**RE: Wilson Warehouse
6119 Hanover Rd. NW
Grading and Drainage Plan
Engineer's Stamp Date: 03/25/19
Hydrology File: J10D045**

RE: Wilson Warehouse @ 6119 Hanover Rd NW
Grading and Drainage Plan Resubmittal, Hydrology File J10D045

Grading Plan

Grading Plan

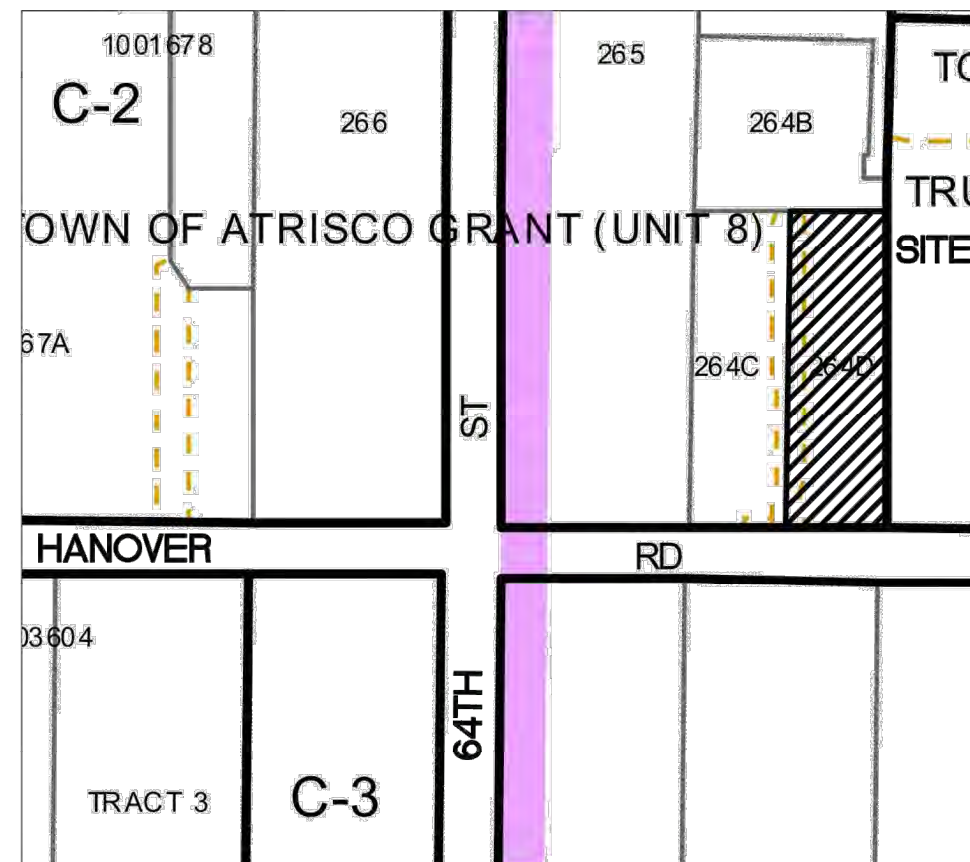
1. The drainage calculations provided on the original approved plan contained some mathematical errors and did not match those as required by the DPM. We have updated the drainage basin table to match the DPM and double checked the calculations manually. The Land Treatment values for the Developed conditions match those that currently exist on site.

2. The note to fix the existing pipe has been added.
3. We have added the SO-19 permit notes and the signature line.
4. The note has been added to the plan.

5. The calculations provided on the revised plan reflect current conditions for Tracts 264-B and 264-C. Tract 264-D reflects the proposed conditions from this project. Our calculations, based directly on the DPM, show that the 100-Year, 6-Hour volume generated by the entire site is 12,264 cubic feet. The actual volume of the existing pond is 14,241 cubic feet up to elevation 5096.00; with excess capacity up to an elevation of 5097.00. Since the pond is a retention pond and capturing 100% of the flows generated by the site, no routing is required. The pump and pipe outlet previously installed was provided in order to slowly drain the pond into Hanover Rd NW after the storm has subsided.

Grading Plan

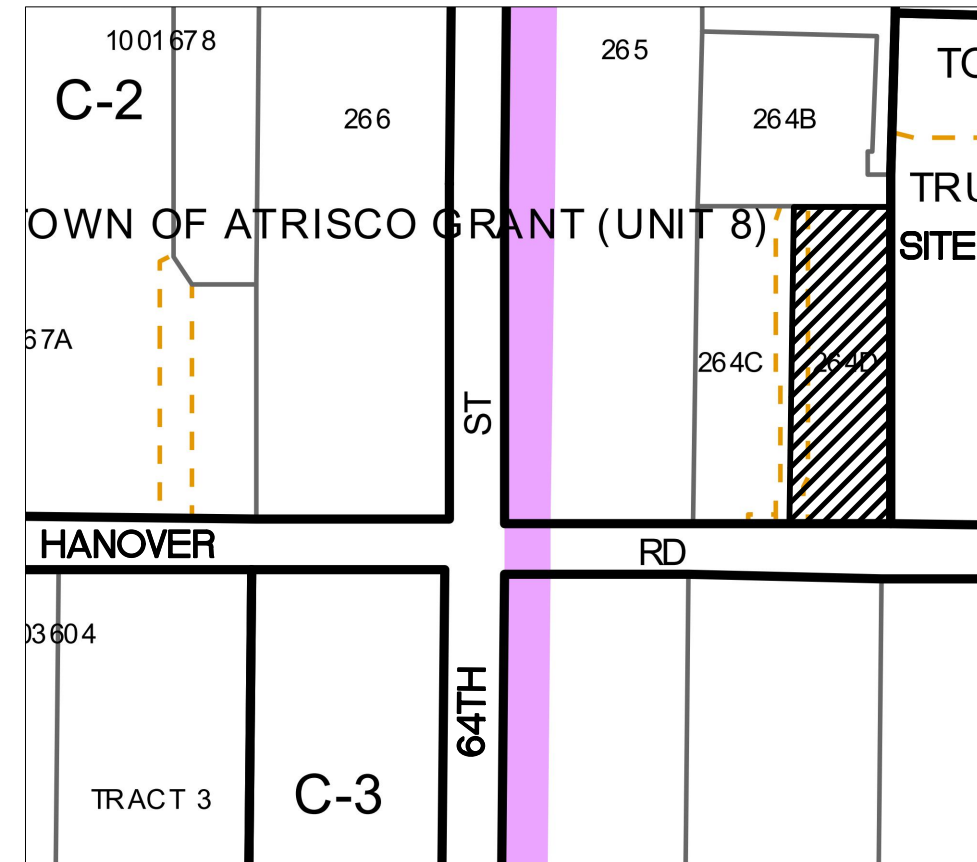
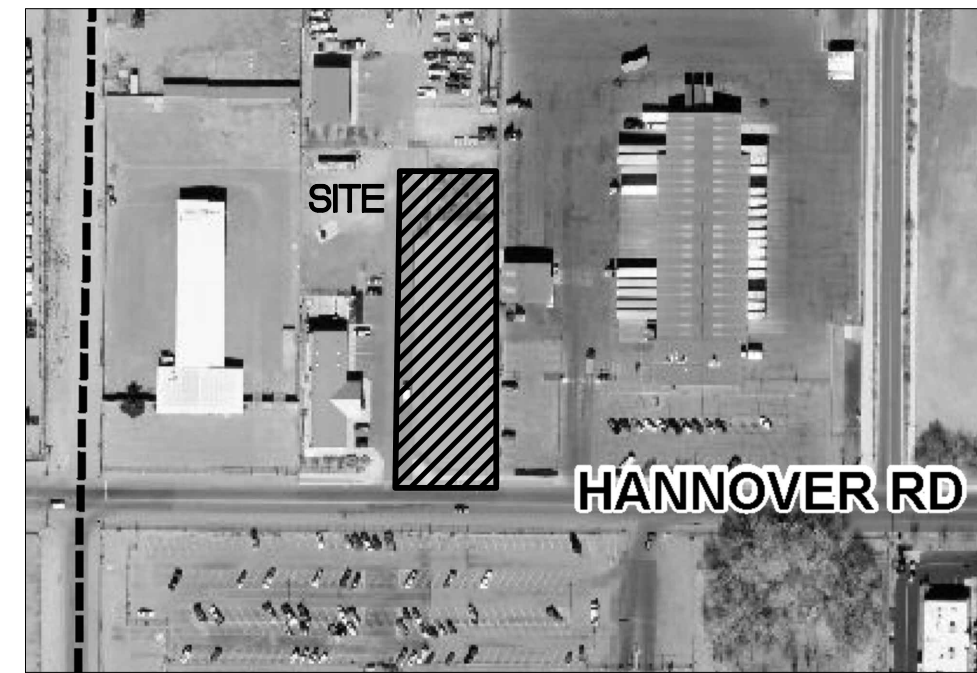
We are in receipt of your comments dated March 19, 2019 regarding the subject project. The revised plans are included with this resubmittal. Below are responses to your comments.

6. The detention (retention) pond does not need to be enlarged; therefore, the new spillway will not be required.
7. A Drainage Covenant will be provided as requested prior to CO request.

PVC pipe draining
must remain in
all times. If this pipe
during construction,
it must be fixed.

The existing PVC pipe draining
the pond was disconnected at
by the ABCWUA. The Contractor
must replace/fix this PVC pipe
through the curb using COA Std
Dwg 2235 and via SO-19 Permit.
